320230621P

Application for a non-material amendment following a grant of planning permission.

Proposed two-storey extension to side and single-storey extension to rear.

3/2022/0863

Proposed Side Elevation 1:50

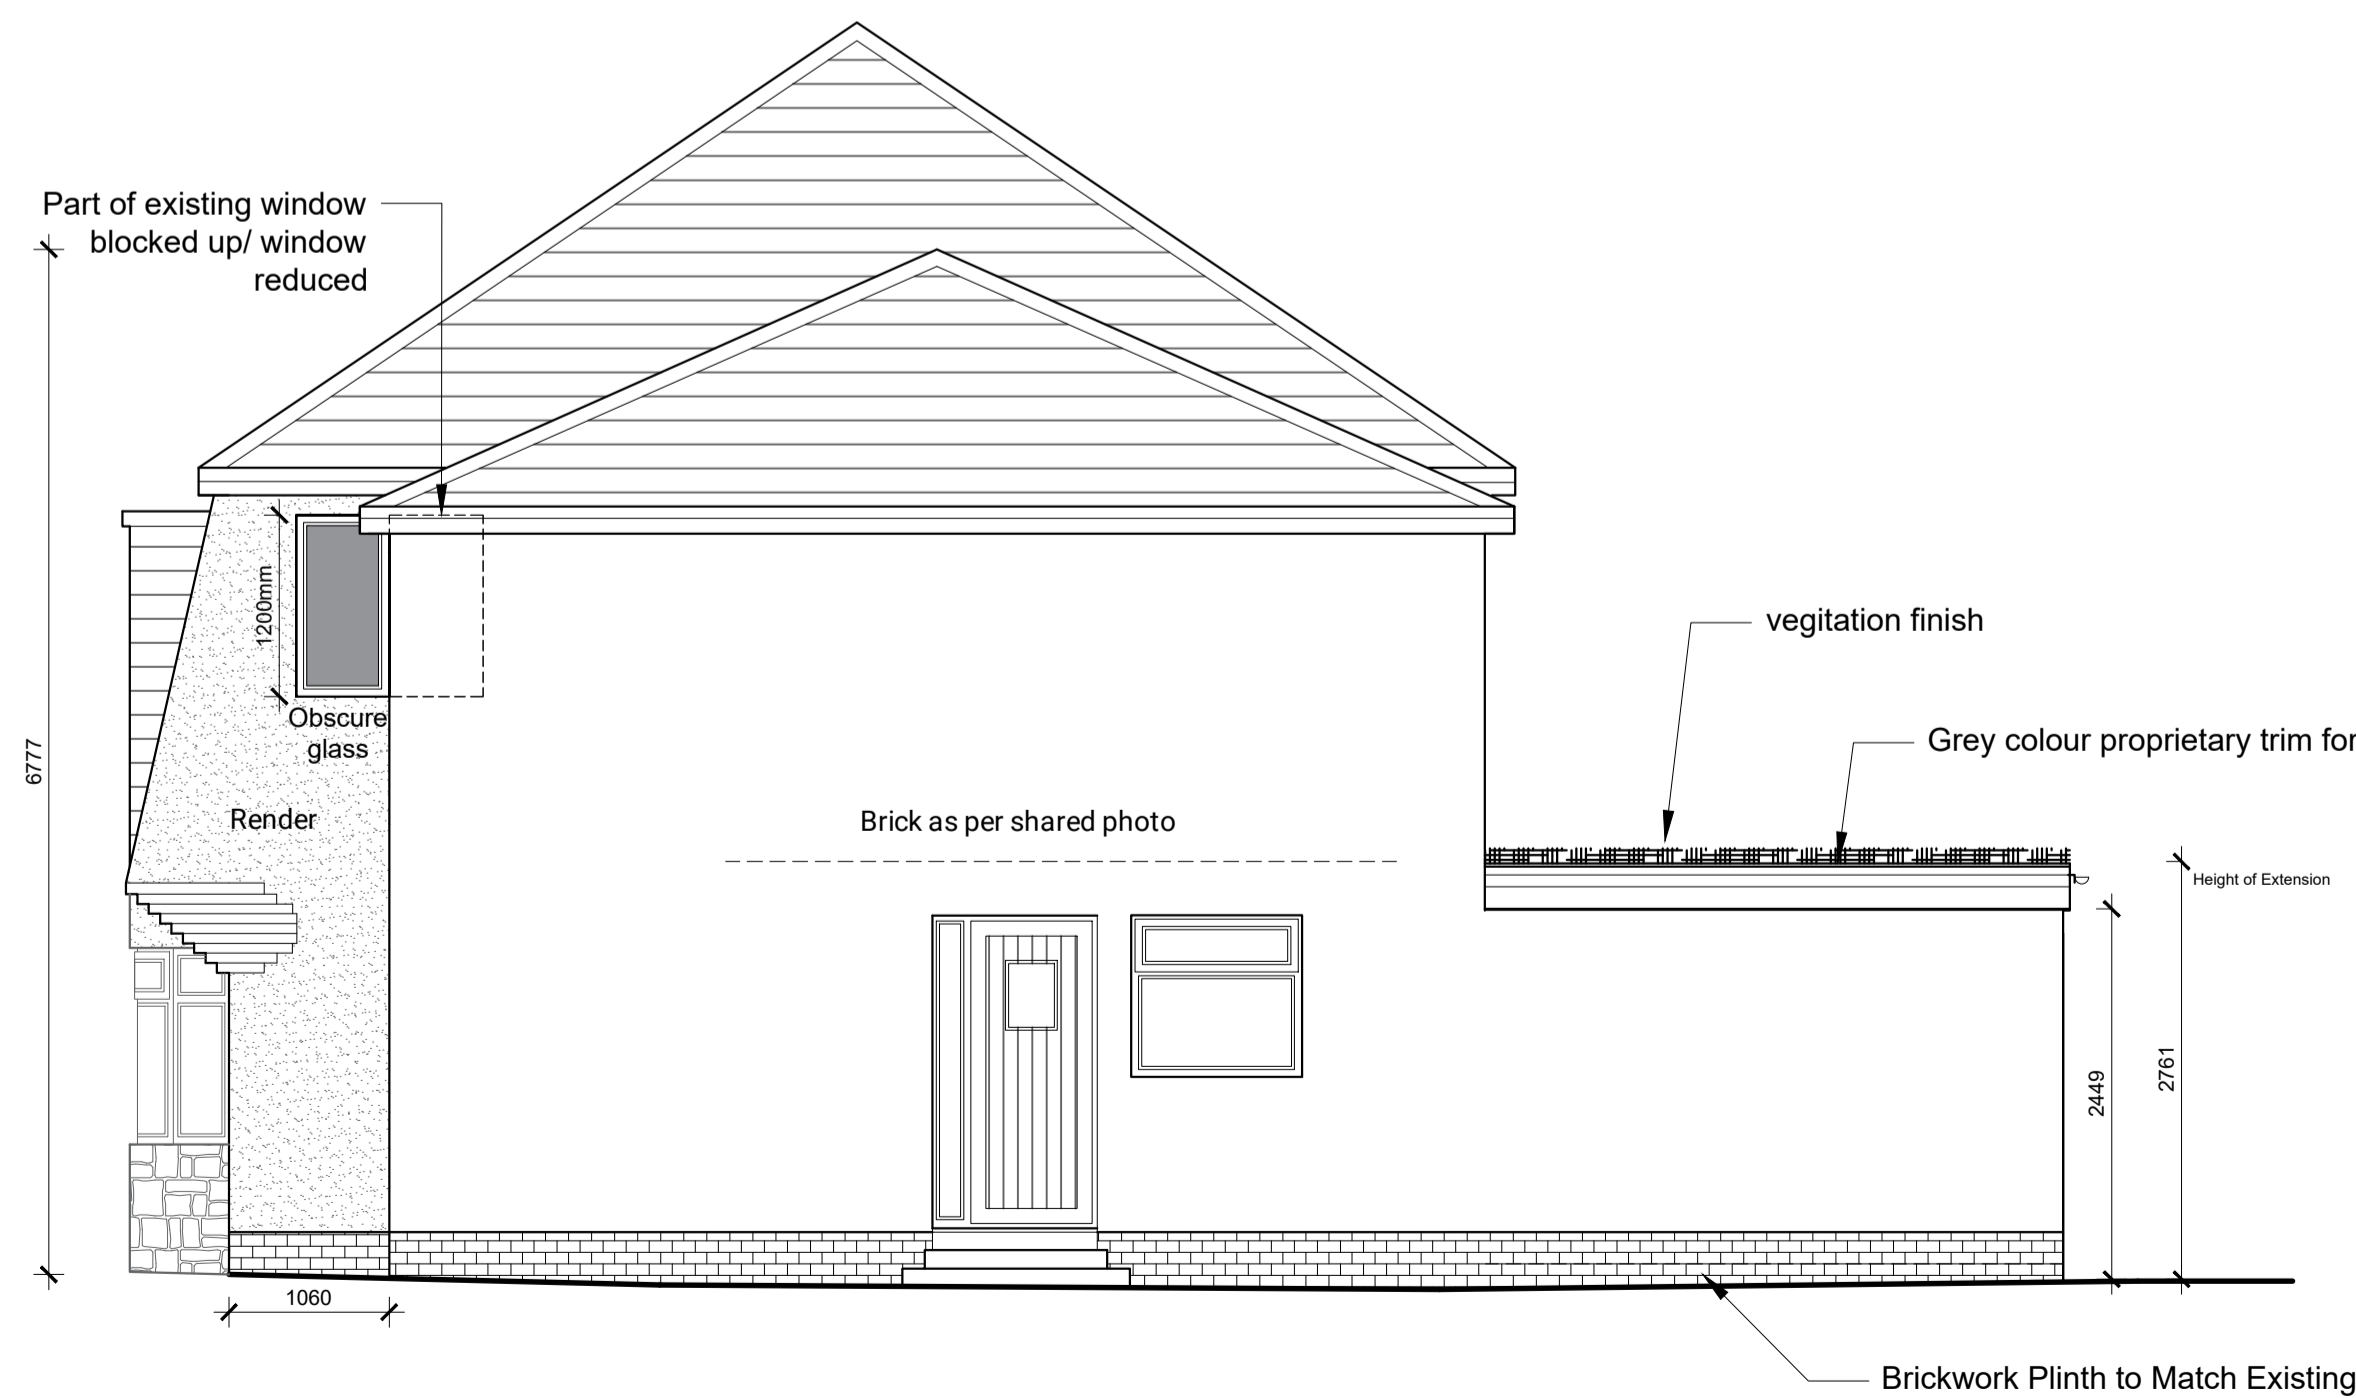
- 1 - Stone cladding finish on the side facade close to number 13, which has replaced the original plan for render
- 2 - Maintain a smaller bathroom window on the current family bathroom (in the same location as previously, but smaller)
- 3 - Timber cladding on the rear facade of the single story rear extension to be vertically mounted and not horizontal (with a material change from cedar to another wood)

- 1 - It became apparent that it was an impossible task to practically tender this facade due to the close proximity to number 13. Stone was chosen to match with the existing stone finish on the front facade of the house. This can be installed as the wall is built rather than having unsafe access challenges trying to render.
- 2 - To ensure suitable and sufficient ventilation and the ability to have natural air within the bathroom.
- 3 - Cedar is seemingly a very very expensive option and was annotated on the plan as a last minute change during planning. Timber will still be used but a more affordable option researched. Vertical mounted rather than horizontal for aesthetics.
